Our ref: RA/2013/124649/01-L01
Your ref: 2013/60/90249/E
Date: 25 March 2013

OUTLINE APPLICATION FOR ERECTION OF 106 DWELLINGS, DEMOLITION OF EXISTING BUILDINGS AND REMOVAL OF DISUSED RAILWAY EMBANKMENT LOCK STREET, THORNHILL, DEWSBURY

PROPOSED SITE PLAN

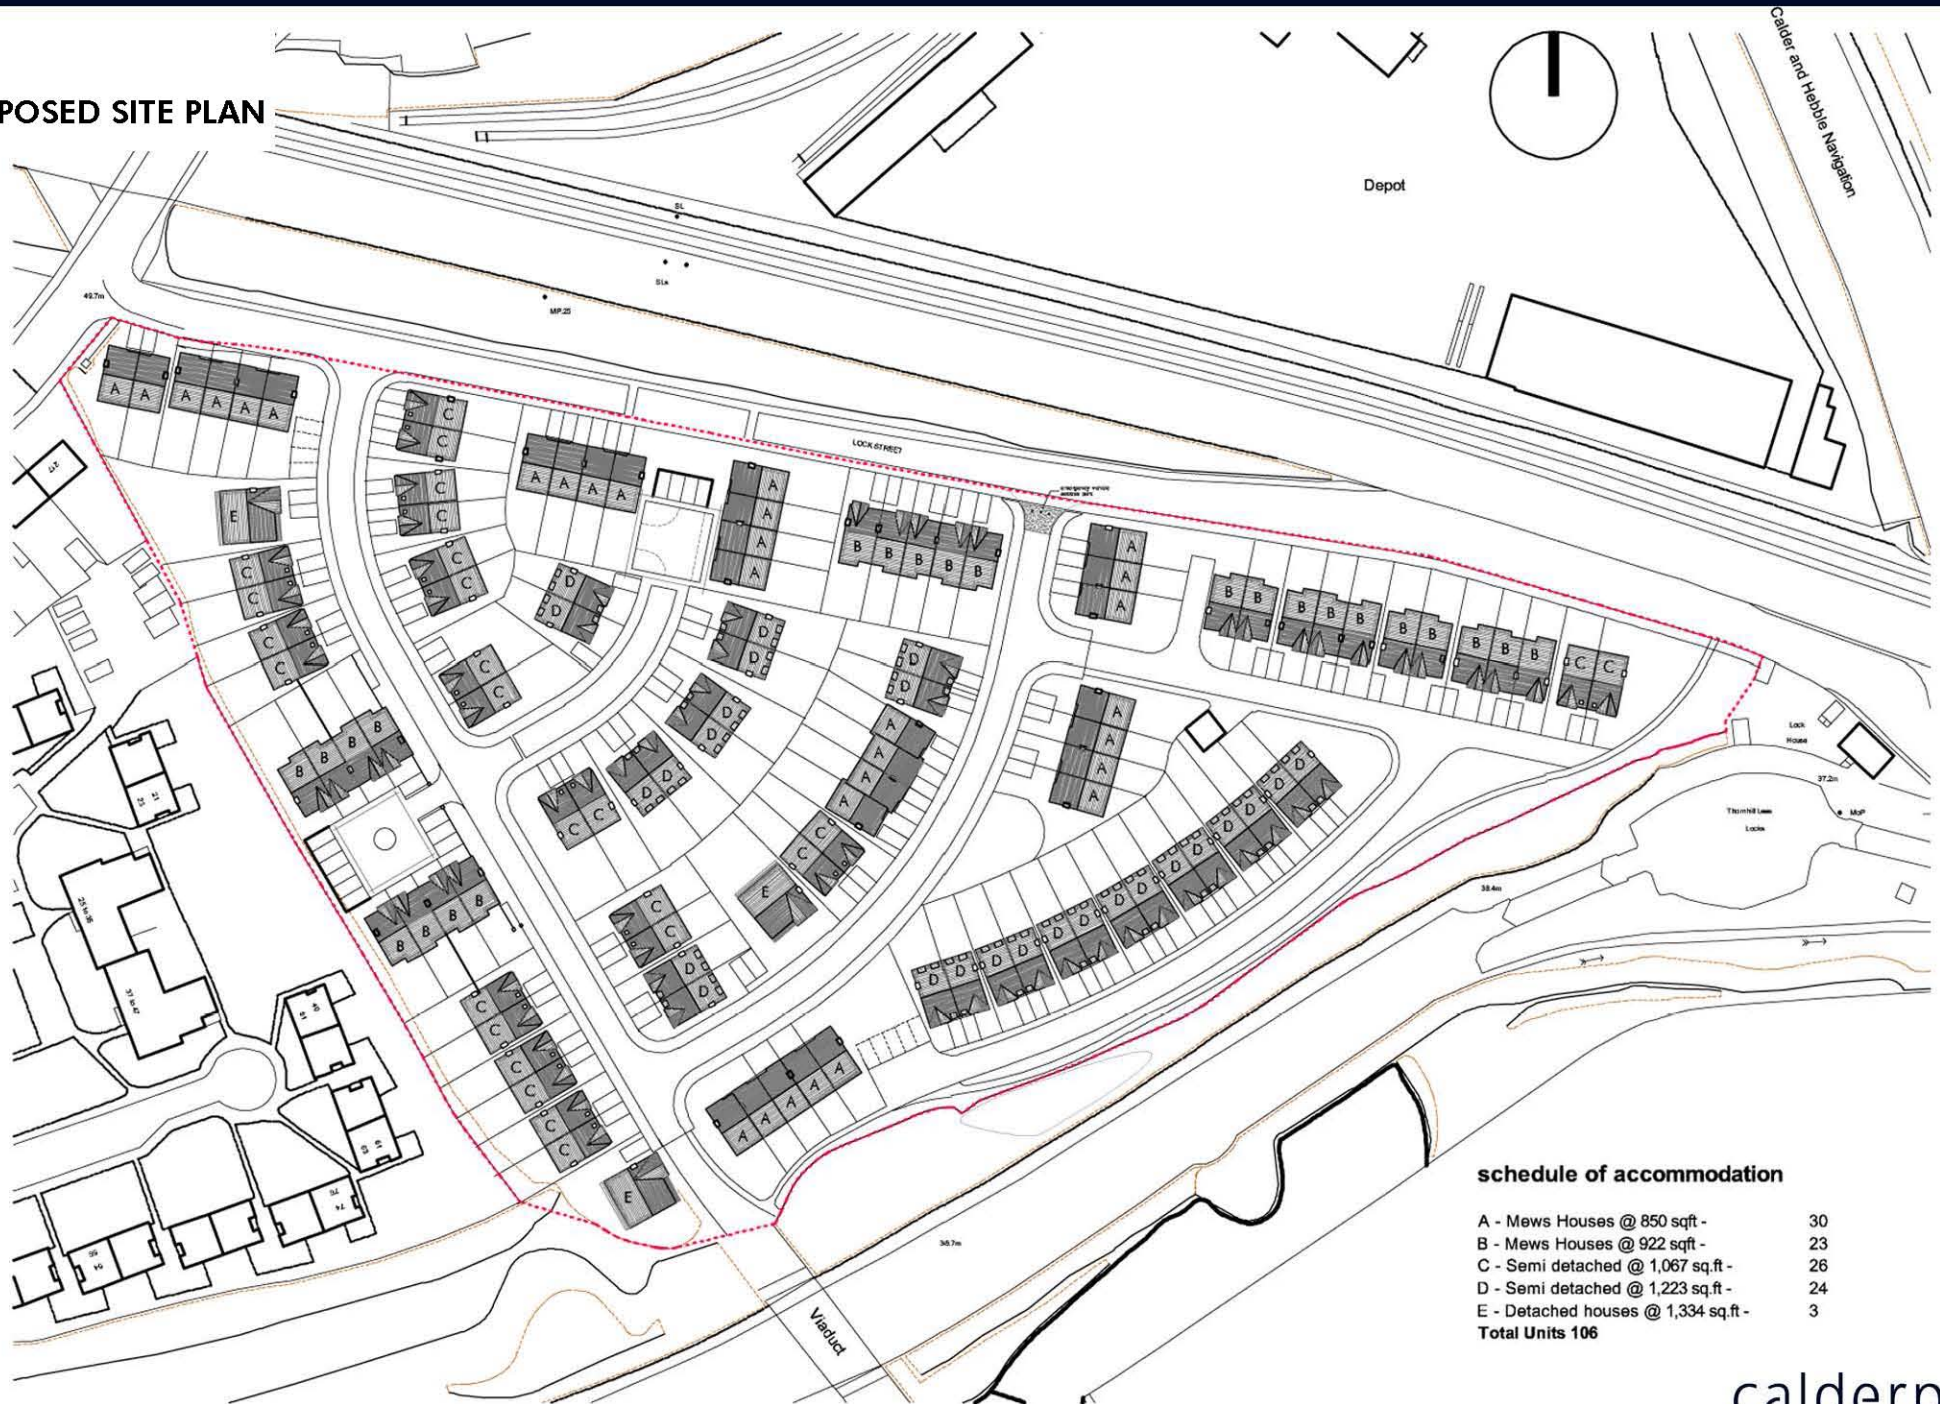
The proposed site layout as shown on the Design and Access Statement and the Proposed Site Plan shows housing and the access road to be nearer the canal than what is recommended in the Ecological Assessment June 2012. This reduces the buffer to the canal significantly, increasing light spillage and causing disturbance to commuting/foraging bats using the canal corridor. Therefore the design should be altered to ensure protection of the green corridor and bats' using it is maintained.
